Section 55: Acceptance of Applications

A303 Sparkford to Ilchester Dualling: Section 55 Application Checklist¹

A303 SPARKFORD TO ILCHESTER DUALLING
WORKS PLANS REGULATION 5(2)(J)
SHEET 2 OF 4

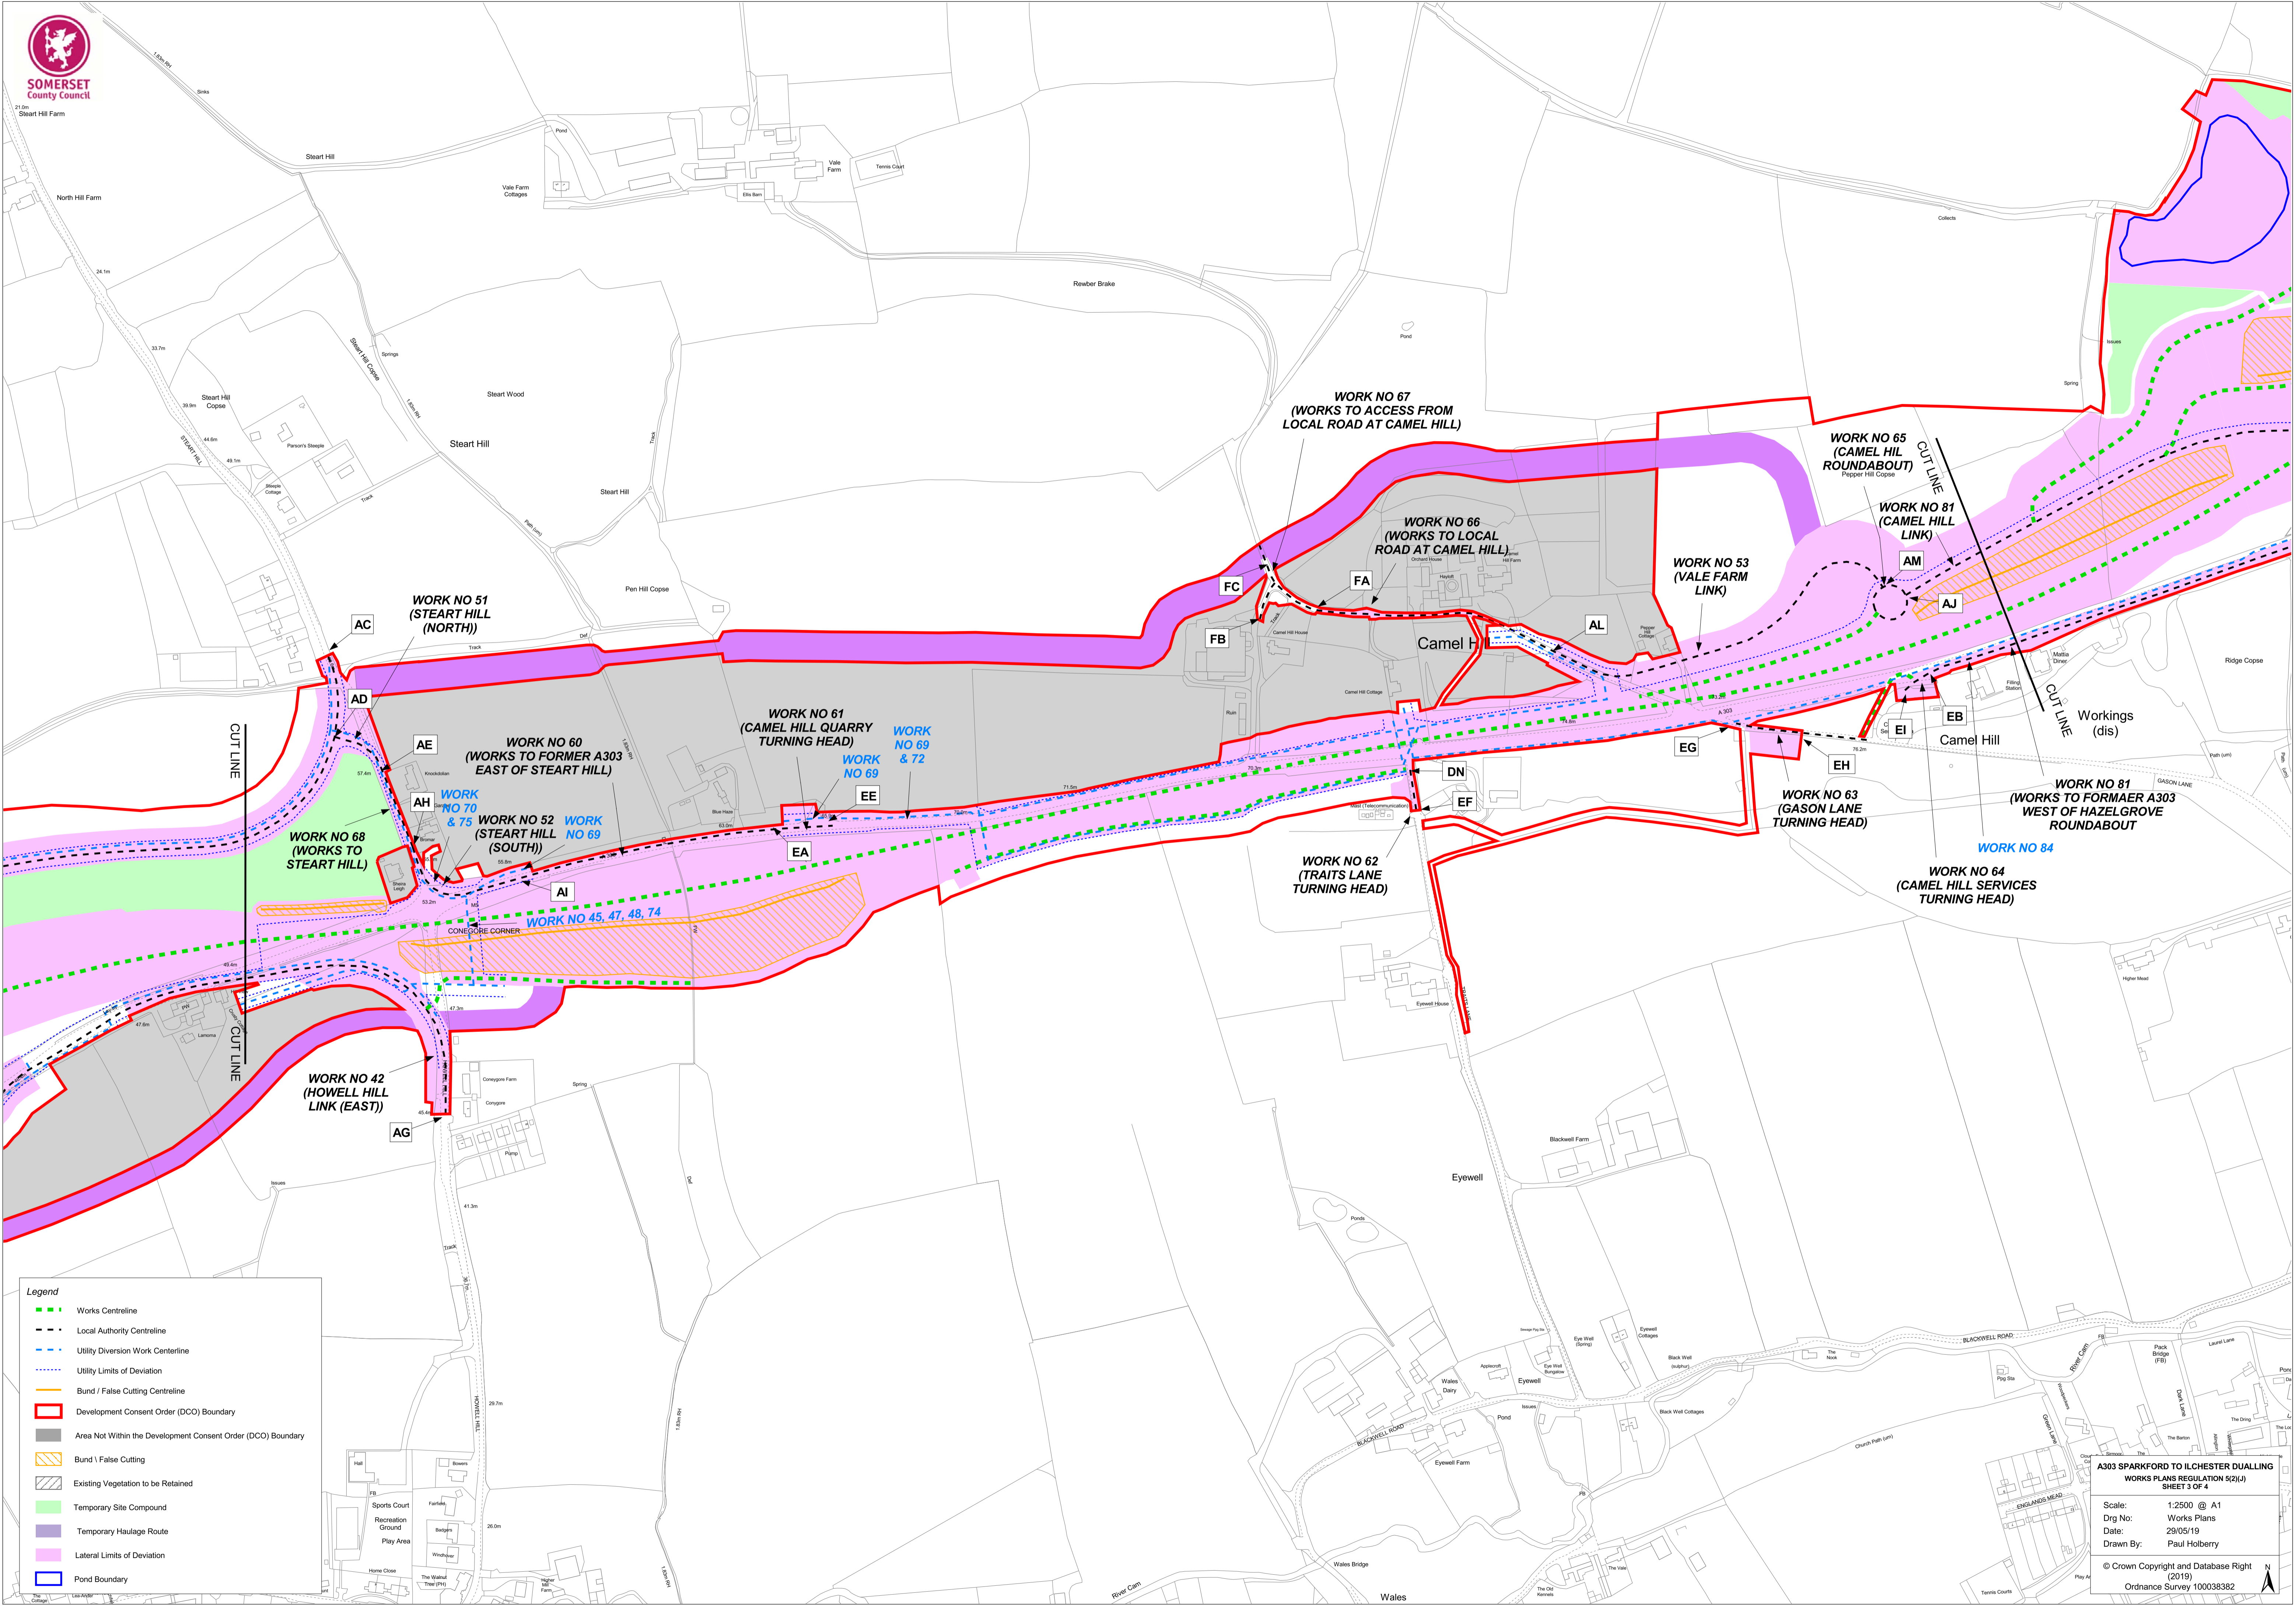
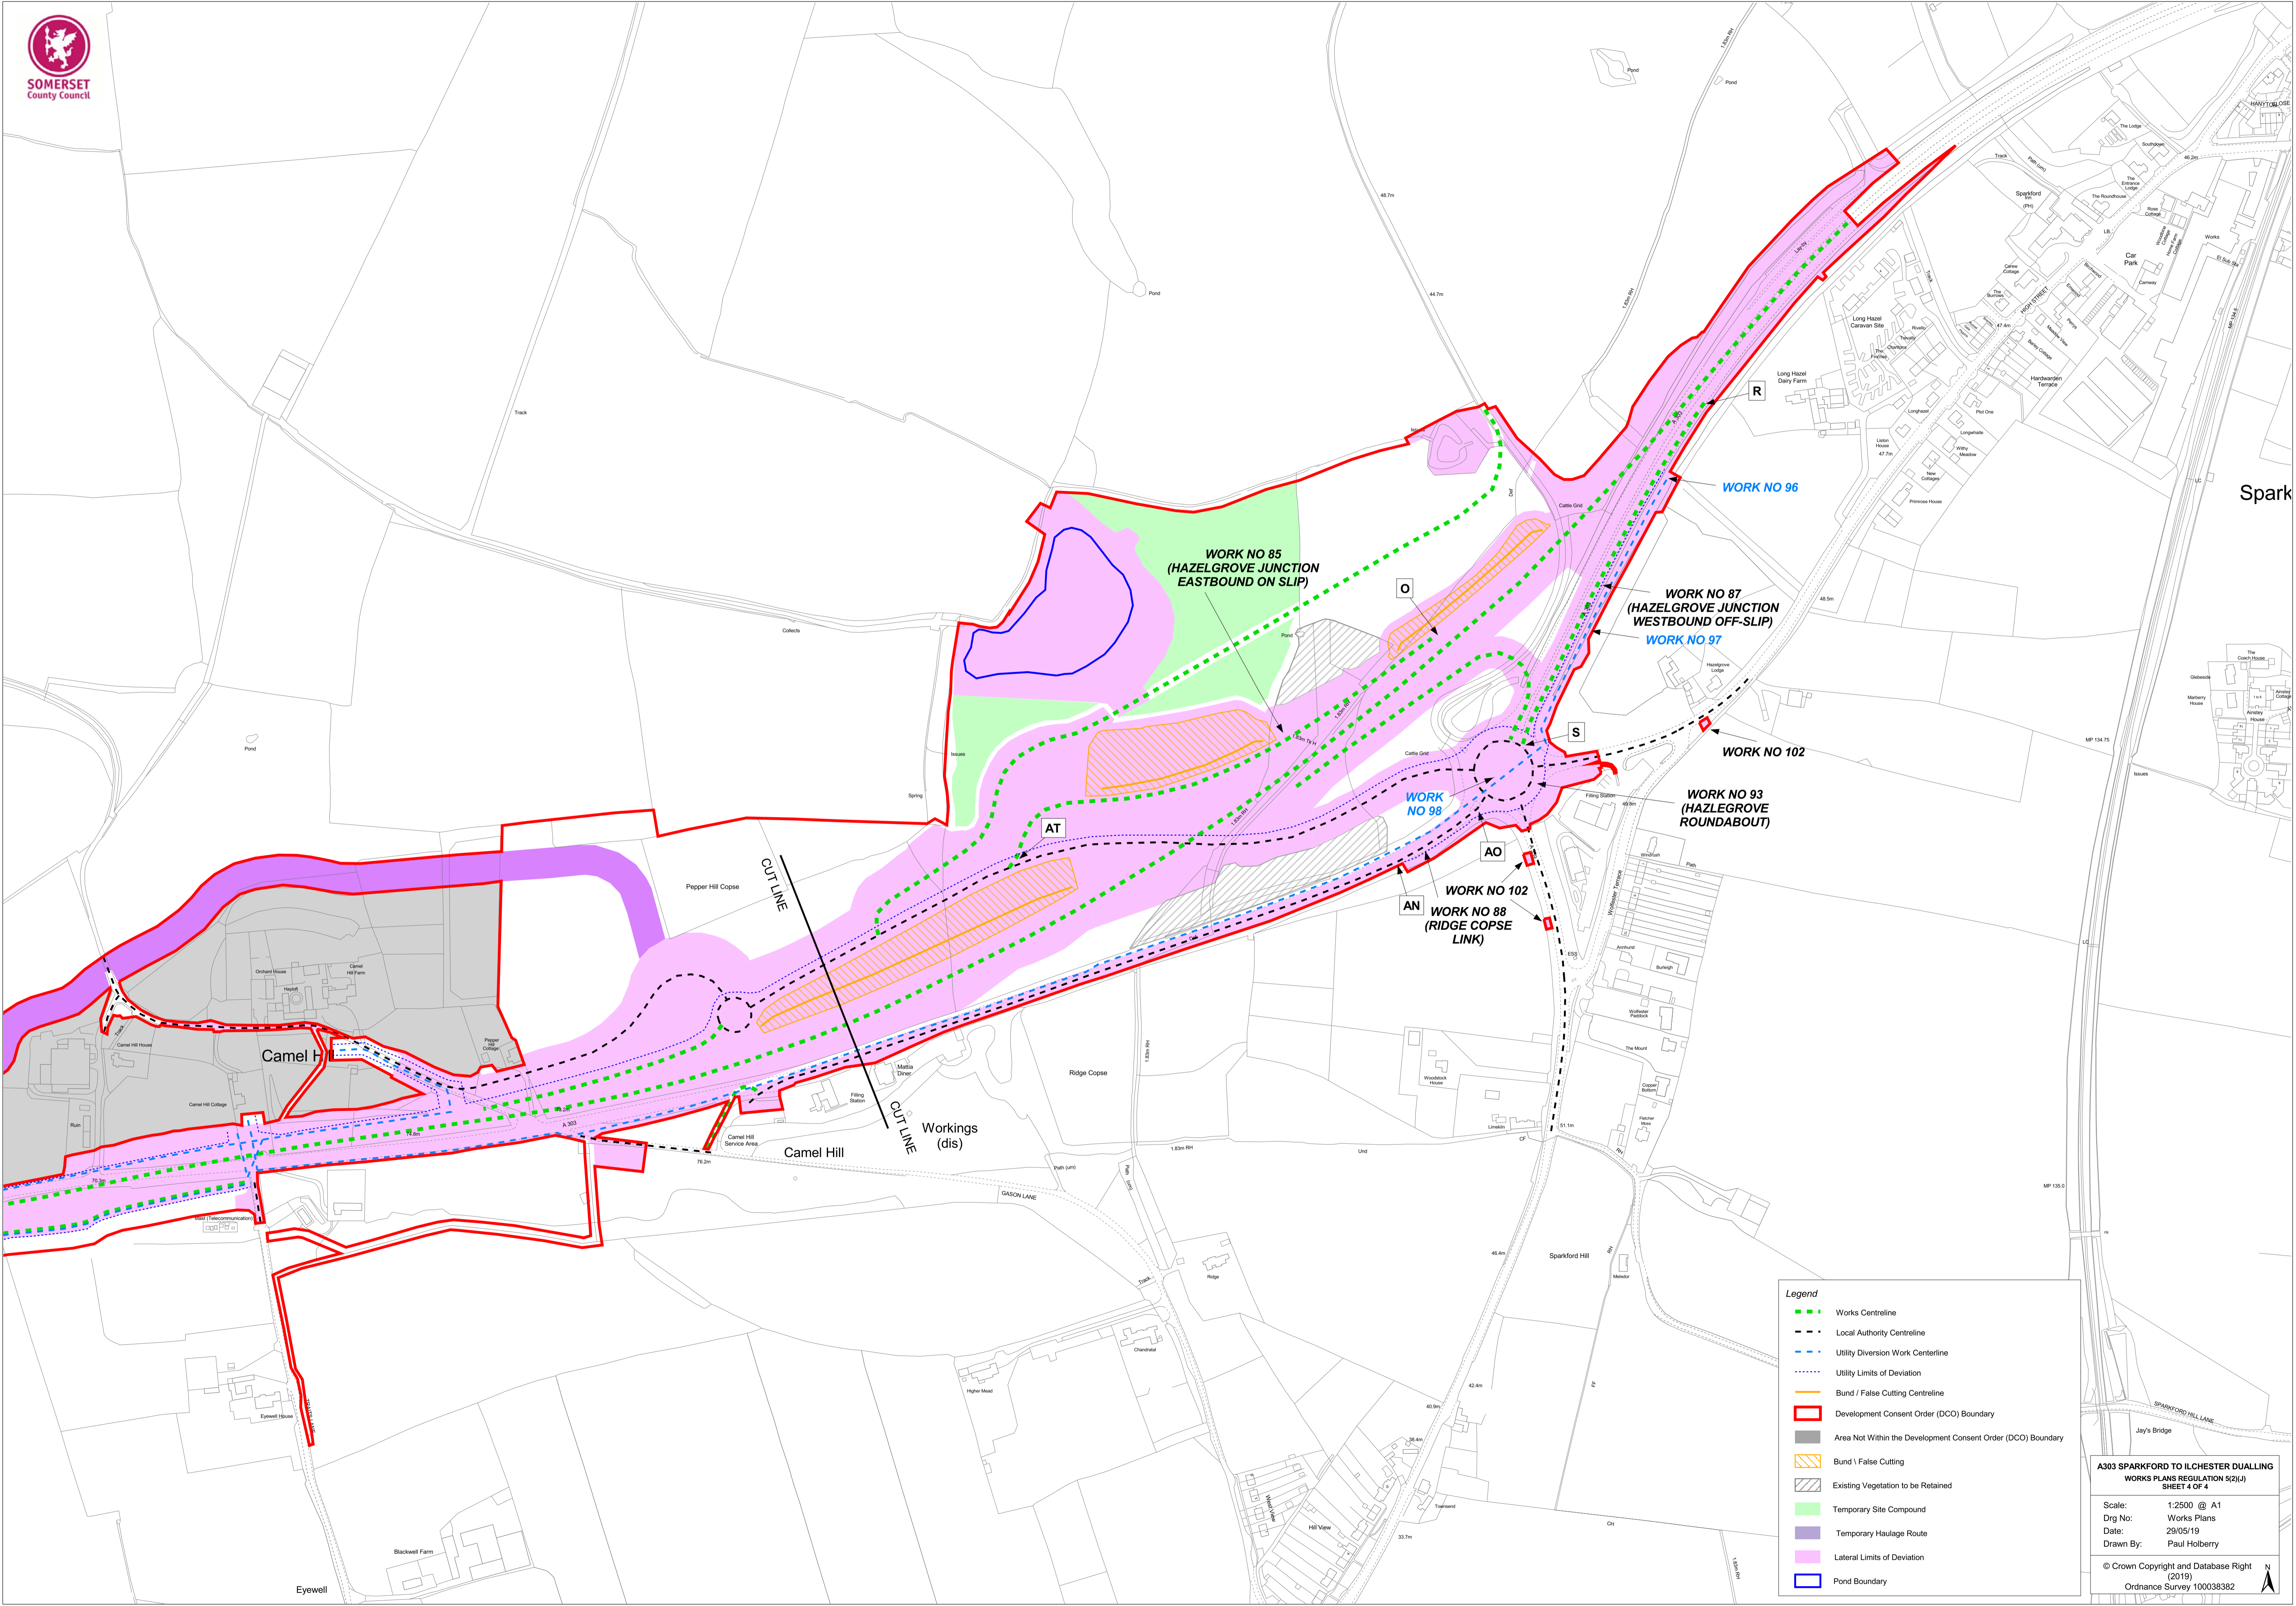
Work No.12 in **Schedule 1** of the **Draft Development Consent Order (Document 3.1)** refers to point 'DE'. This point is not marked on the relevant **Works Plan (Document 2.3)**. Similarly Work No. 61 refers to point 'EE' and this point is not marked on the relevant Work Plan.

Work No.10 in **Schedule 1** of the **Draft Development Consent Order (Document 3.1)** refers to an Ecological mitigation area. The limits of deviation for this work are not marked on the relevant **Works Plan (Document 2.3)**.

Work Nos. 43 and 44 in **Schedule 1** of the **Draft Development Consent Order (Document 3.1)** refer to point 'KA' shown on sheets 2 and 3. Whilst 'KA' and 'KQ' are marked on sheet 2 the same point is recorded as 'AC' on sheet 3. Similarly Work No. 75 refers to point 'KQ' on sheet 3. This point is only marked on sheet 2 and the same point is recorded as 'AD' on sheet 3.

Work No.56 in **Schedule 1** of the **Draft Development Consent Order (Document 3.1)** is described as shown on sheet 3, however sheet 4 also gives a location for Work No. 56 and describes this as "WORKS TO FORMER A303 WEST OF HAZELGROVE ROUNDABOUT".

Work No. 68 in **Schedule 1** of the **Draft Development Consent Order (Document 3.1)** is described as shown on sheet 3 between points 'EA' and 'AH'. The Work on the relevant **Works Plan (Document 2.3)** does not point to this location.

Section 51 advice has been issued regarding this matter: <https://infrastructure.planninginspectorate.gov.uk/document/TR010036-000268/>. The
